WEST SUSSEX COUNTY COUNCIL CONSULTATION

TO:	Arun District Council FAO: Raymond Cole
FROM:	WSCC - Highways Authority
DATE:	15 January 2021
LOCATION:	Land To East Of Fontwell Racecourse Fontwell Avenue Eastergate BN18 0SW
SUBJECT:	WA/100/20/DOC Approval of details reserved by condition imposed under APP/C3810/V/16/3143095 (WA/22/15/OUT) relating to Condition Nos 9 - Public Open Spaces, 10 - hard & soft Landscaping, 11 - protection of retained trees, 19 - Construction Management Plan, 22 - decentralised & renewable energy, 25 - Travel Plan and 26 - Non-Motorised User Audit.
DATE OF SITE VISIT:	n/a
RECOMMENDATION:	No Objection / More Information / Modification
S106 CONTRIBUTION TOTAL:	n/a

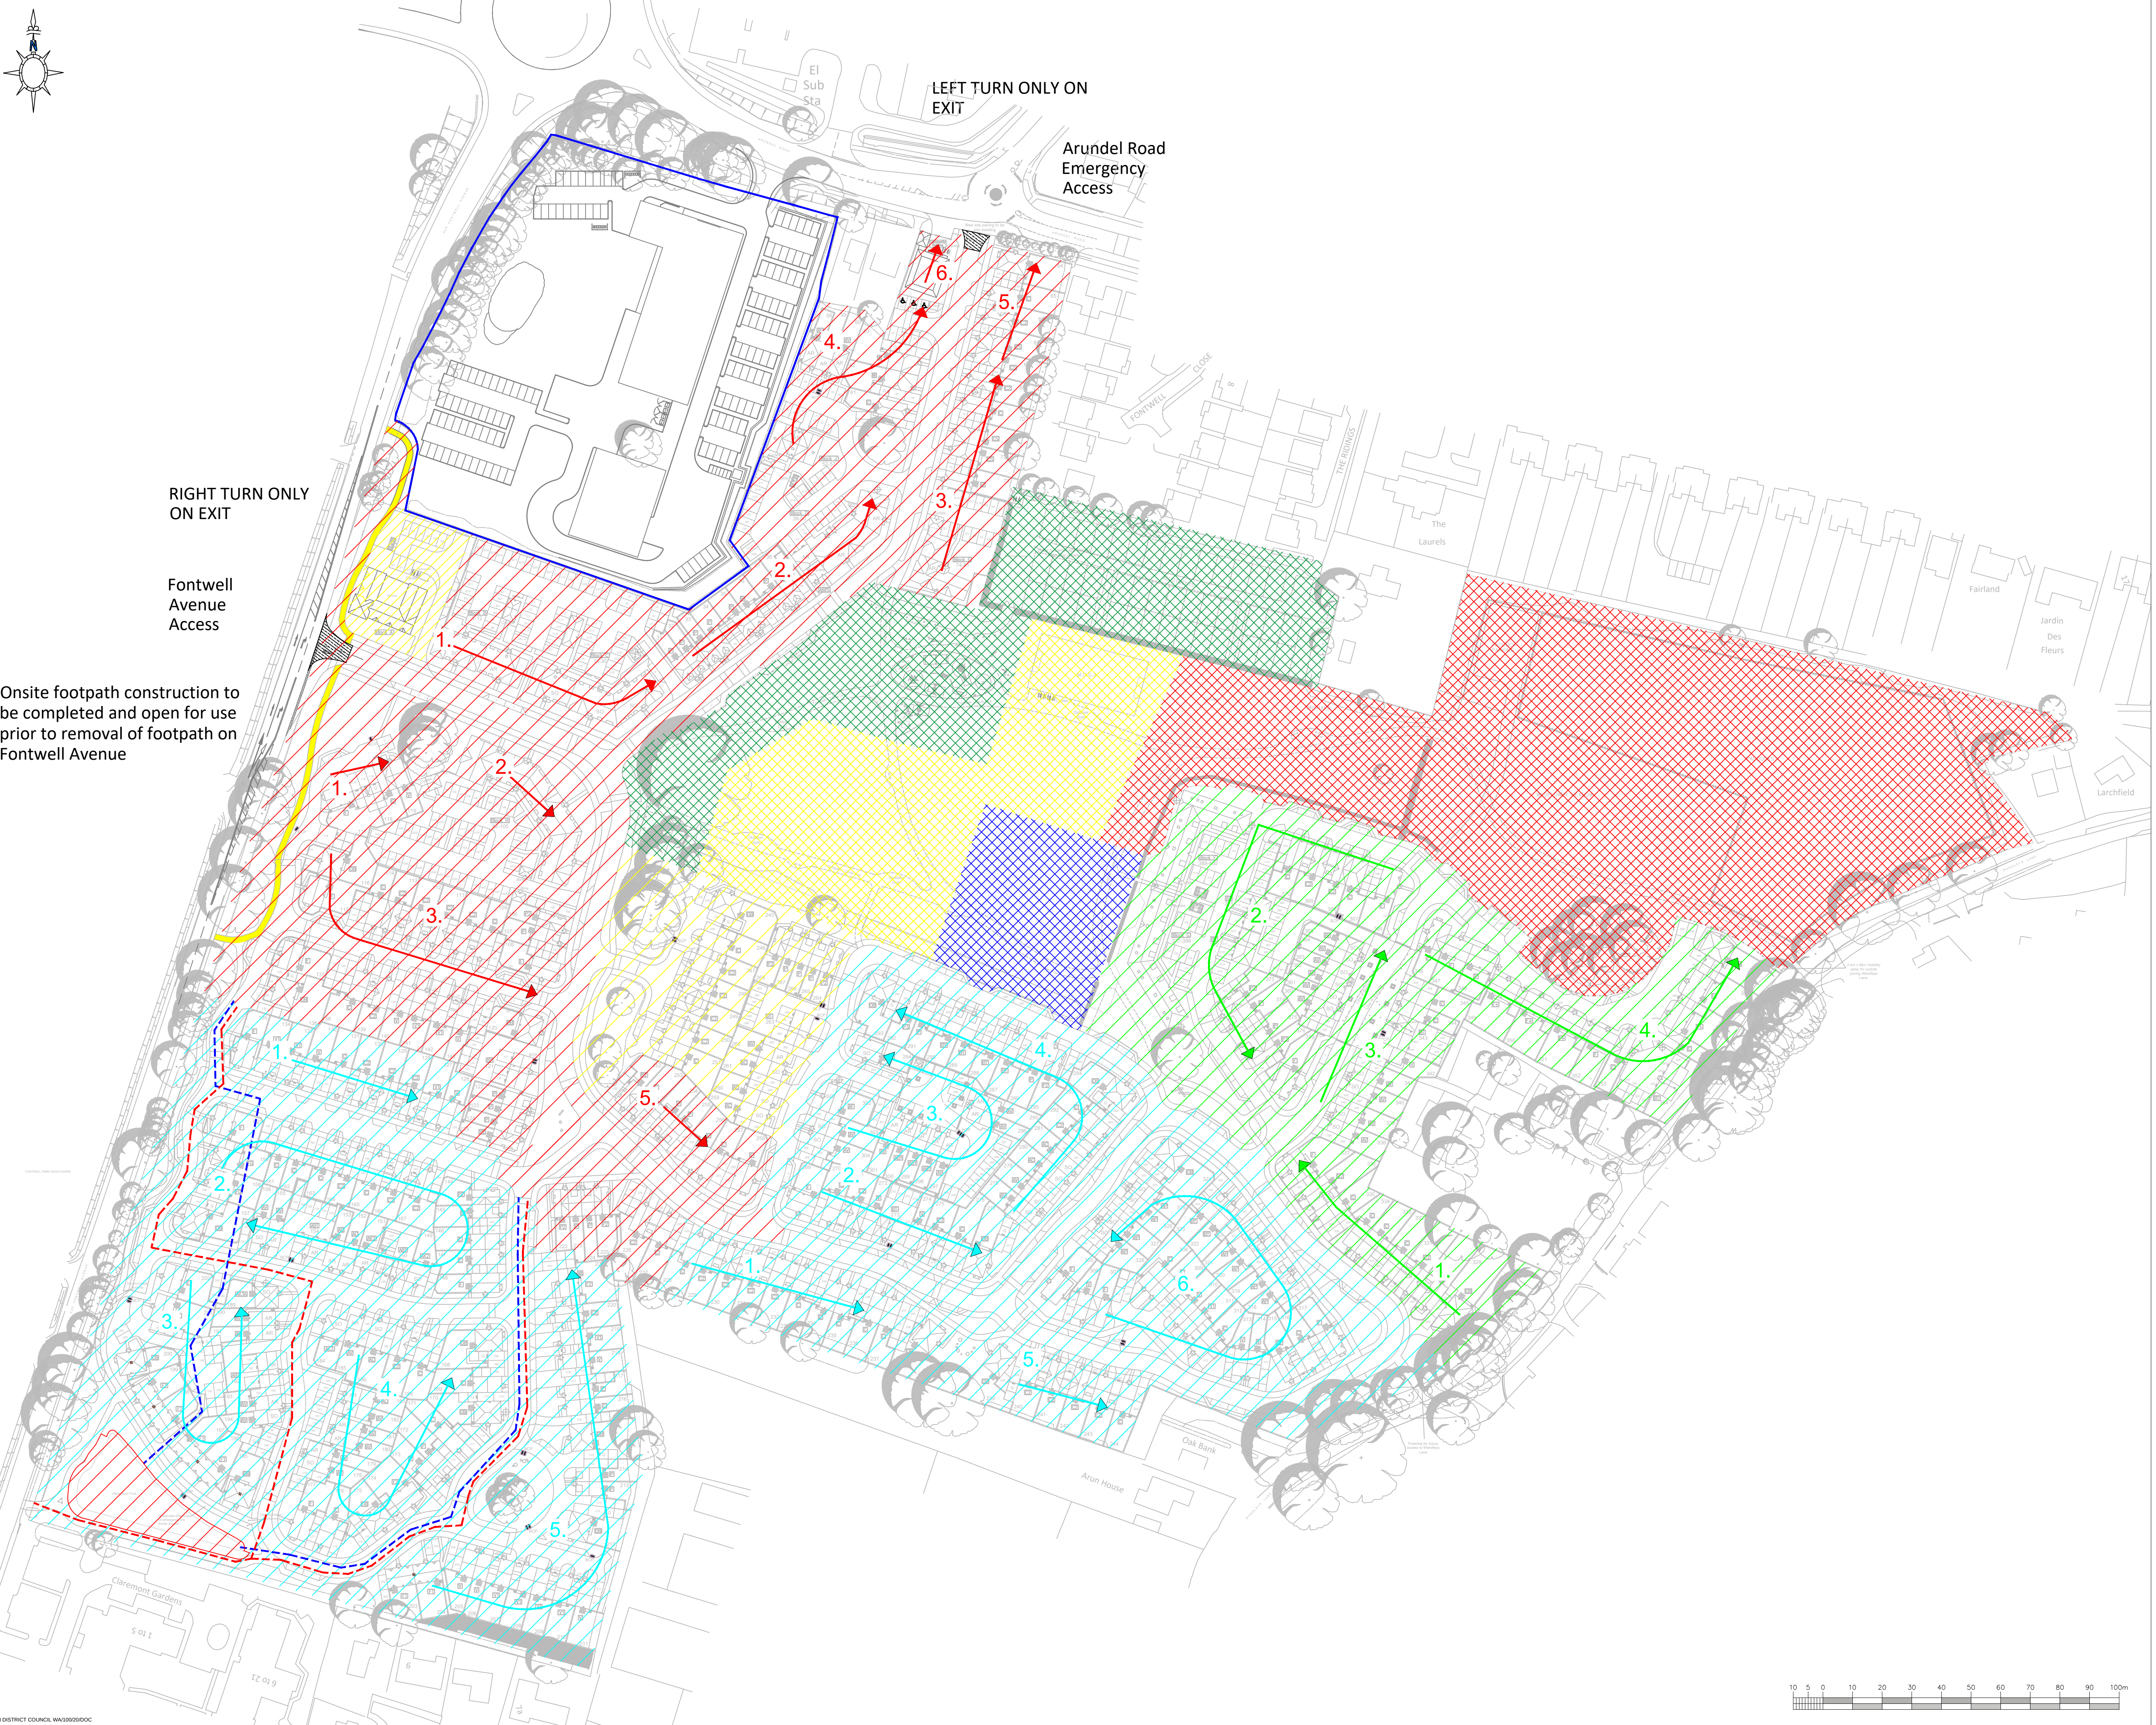
Details should be provided on the timing of access to be provided onto Fontwell Avenue. It is not clear if the applicant intends on the occupation of any dwellings whilst only the access onto Arundel Road is available.

Once the access onto Fontwell Avenue is being utilised details of how the access onto Arundel Road will be restricted and amended into the emergency access only as secured via condition 27 of the original application.
